ENG-CDR23021-R2-CDs-S1.pdf Markup Summary

Subject: SW - Textbox with Arrow
Page Index: 1
Date: 4/2/2024 3:34:42 PM
Author: Glenn Reese - EPC Stormwater
Color: ■
Layer:
Space:
Page Label: [1] 1 COVER

FROM GRANDVIEW FILING 1 TO REX RD (SEGMENT 2)
 STORM PLAN & PROFILE II

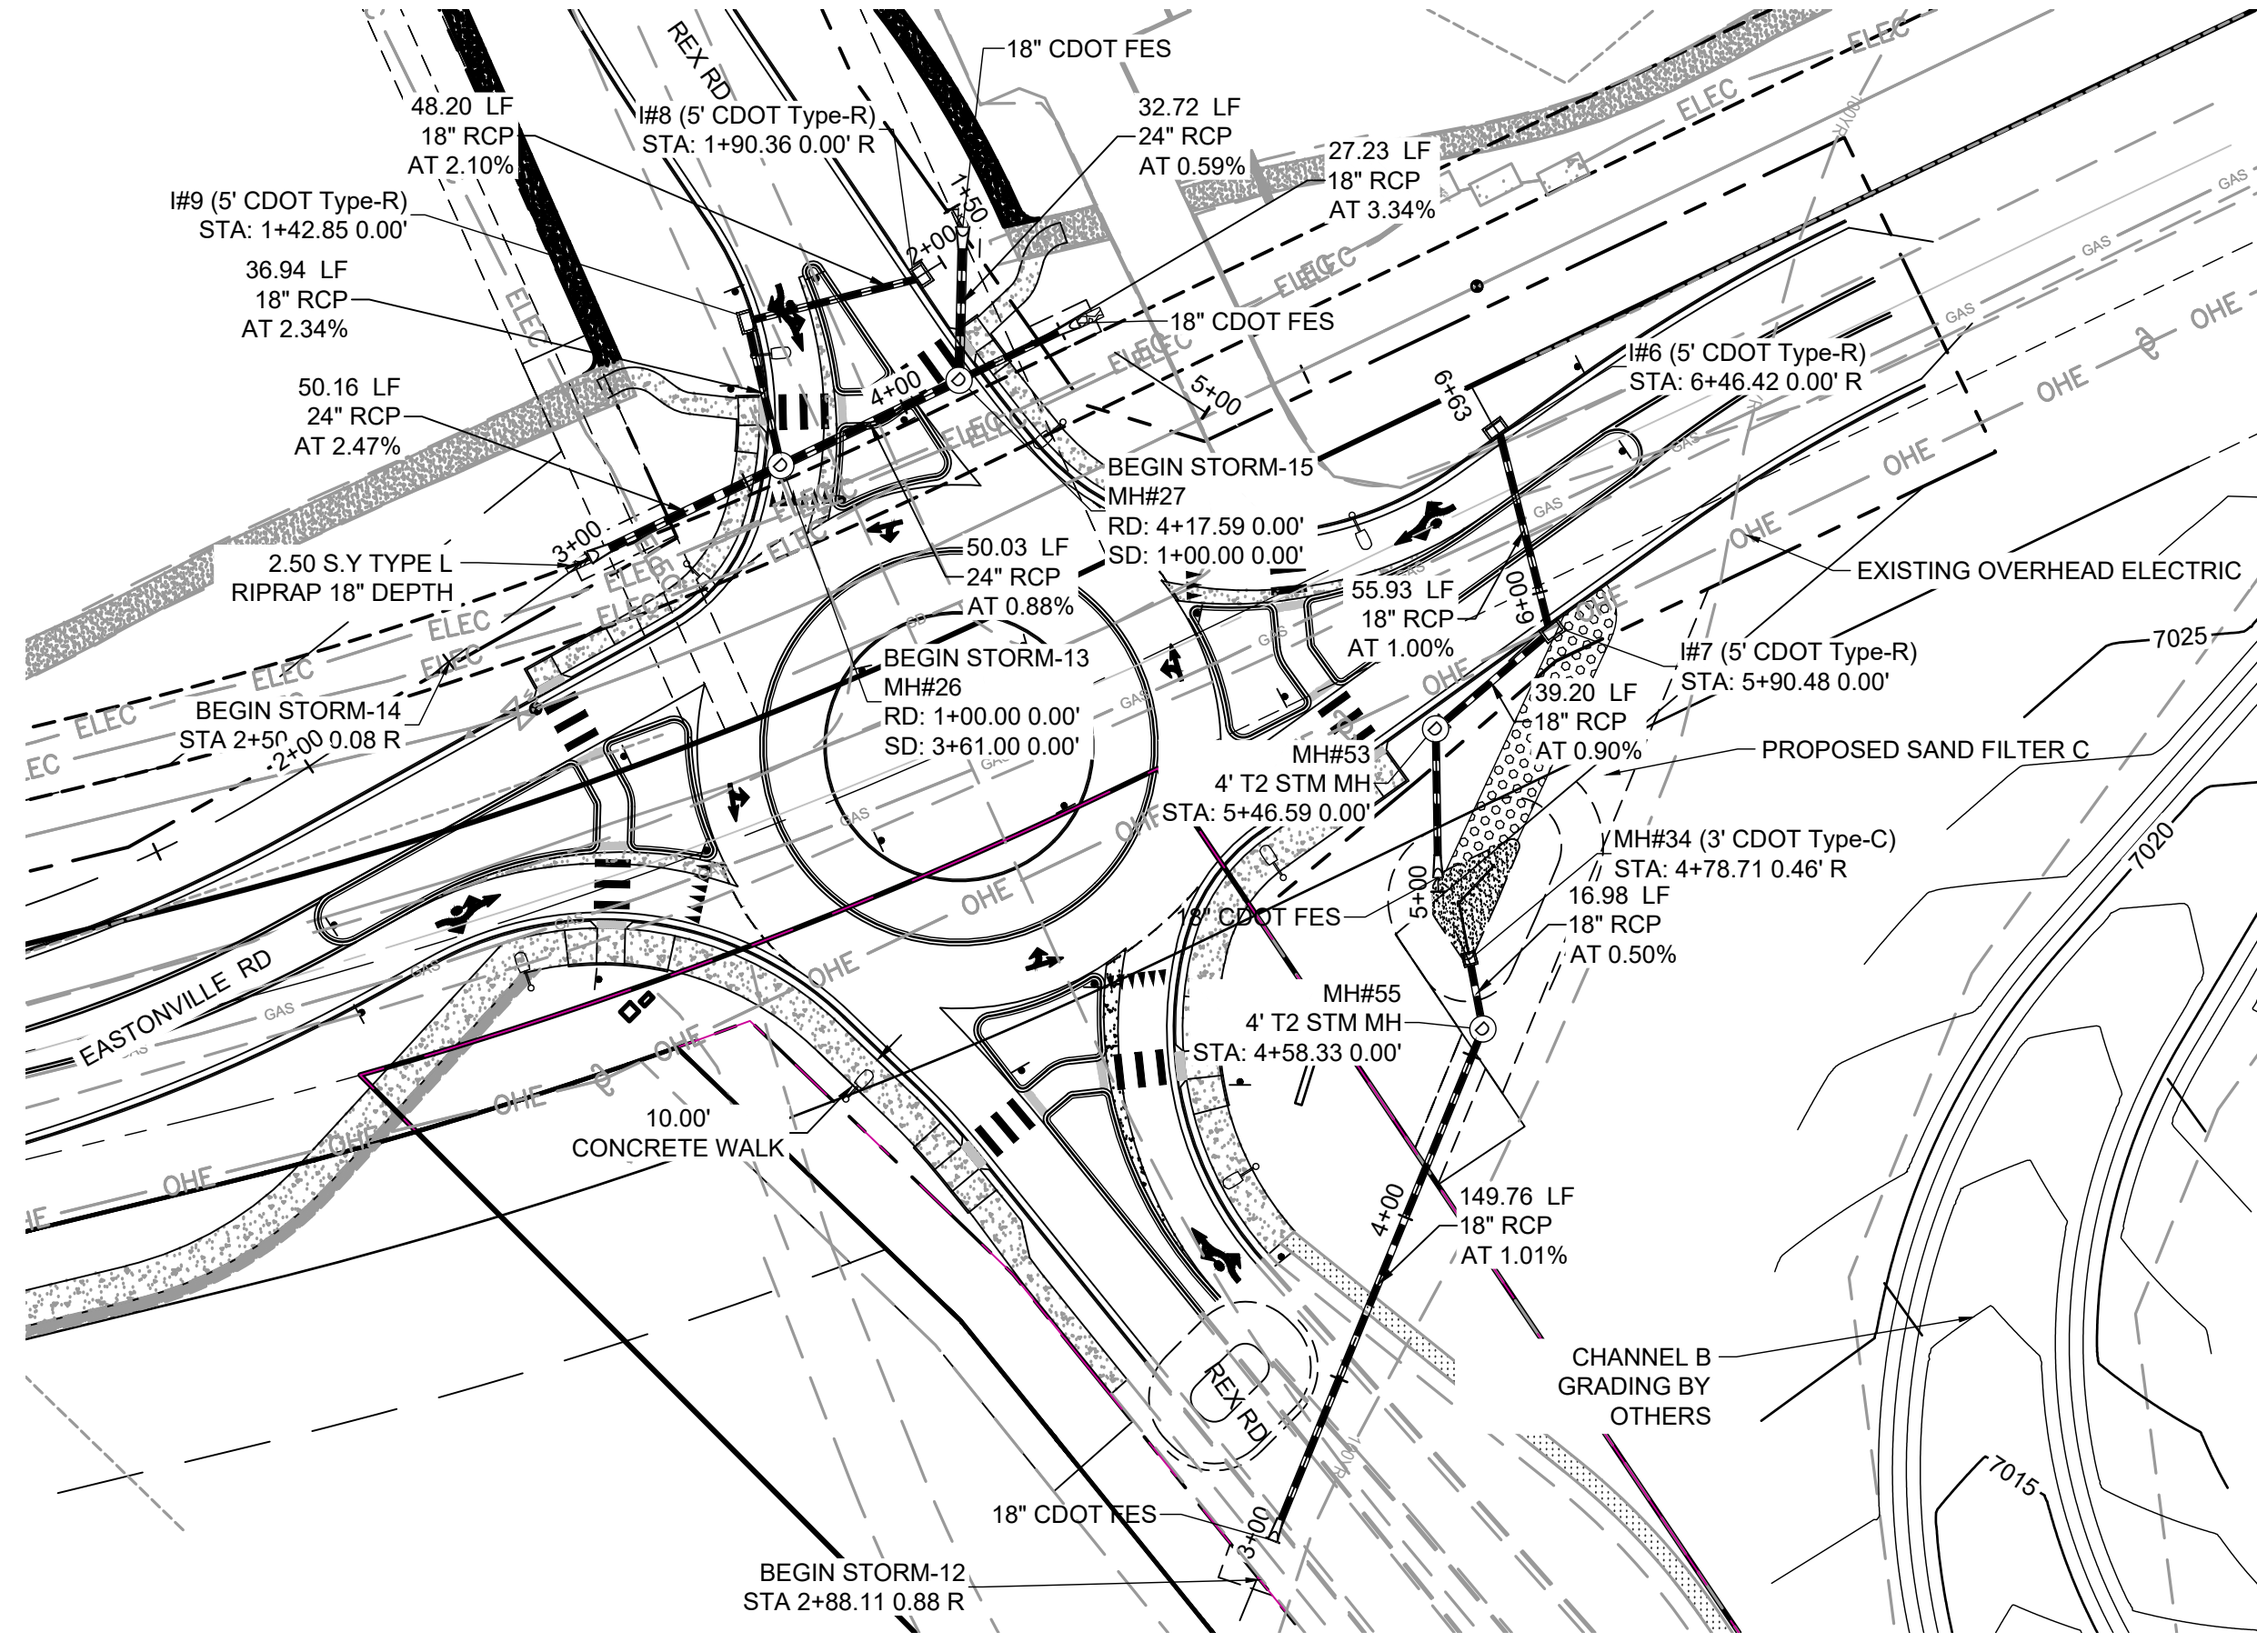
Pipe should not be below grade. Show riprap outlet protection. Provide invert elevation

Slope should not be negative. Please revise

Pipe should reach to proposed grade. Show beginning of forebay. Provide invert elevation

Label manholes

Label all storm infrastructure as public or private (All storm sheets)

Highlighted items do not match with StormCAD information in FDR. Please revise so plans and documents match. (Typical all storm sheets)

Provide detail or additional design information in notes for outlet protection (all storm sheets)

5-yr HGL's need to be shown wherever pipes are surcharged for 100-yr design

For all outlet locations:
 Outfall labeled: end section and headwalls labeled, riprap apron (length, depth, type, D50), toe wall shown, profile of existing ground shown for 200 feet downstream of outfall, Q100 water surface elevation downstream of outfall

SHEET  
**GEC.1** 11

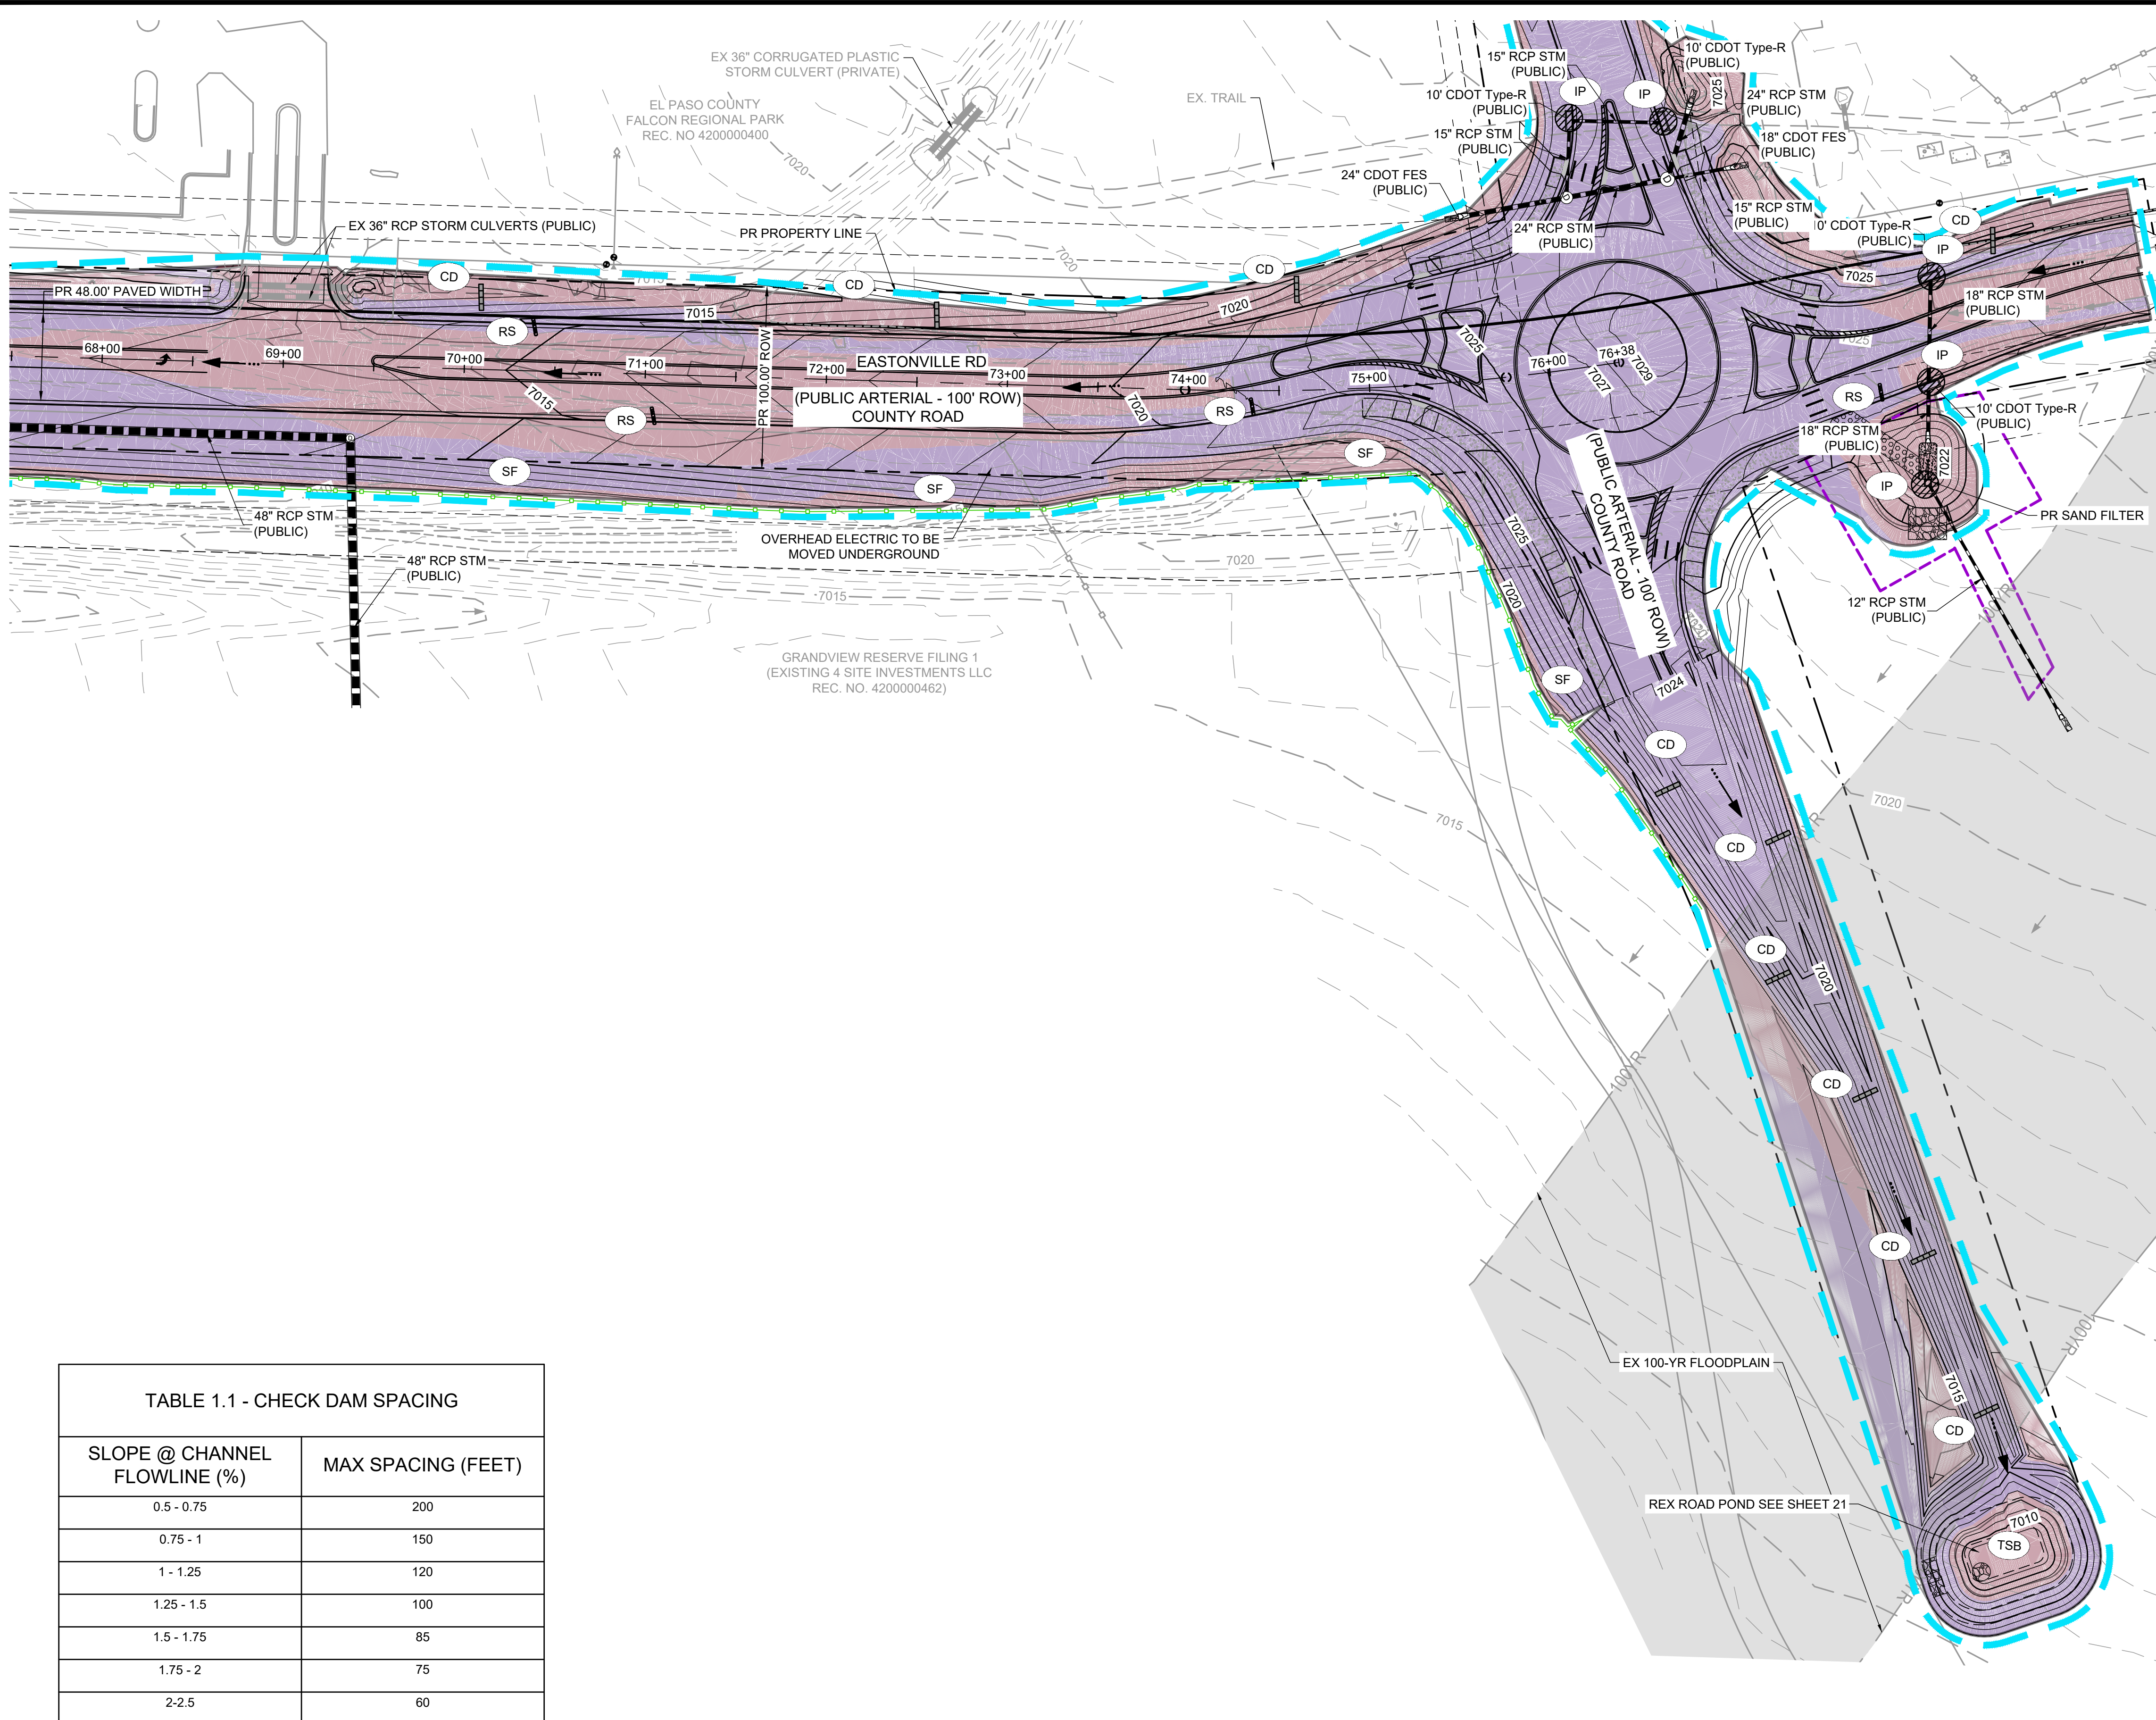
Drainage report calls this SFB D. If it is to be a TSB during construction, clarify that it will be SFB D by the end of construction.

Unresolved:
 Show and label all easements needed

Additional stabilization needed for flows exiting pipes? Easement need for these flows
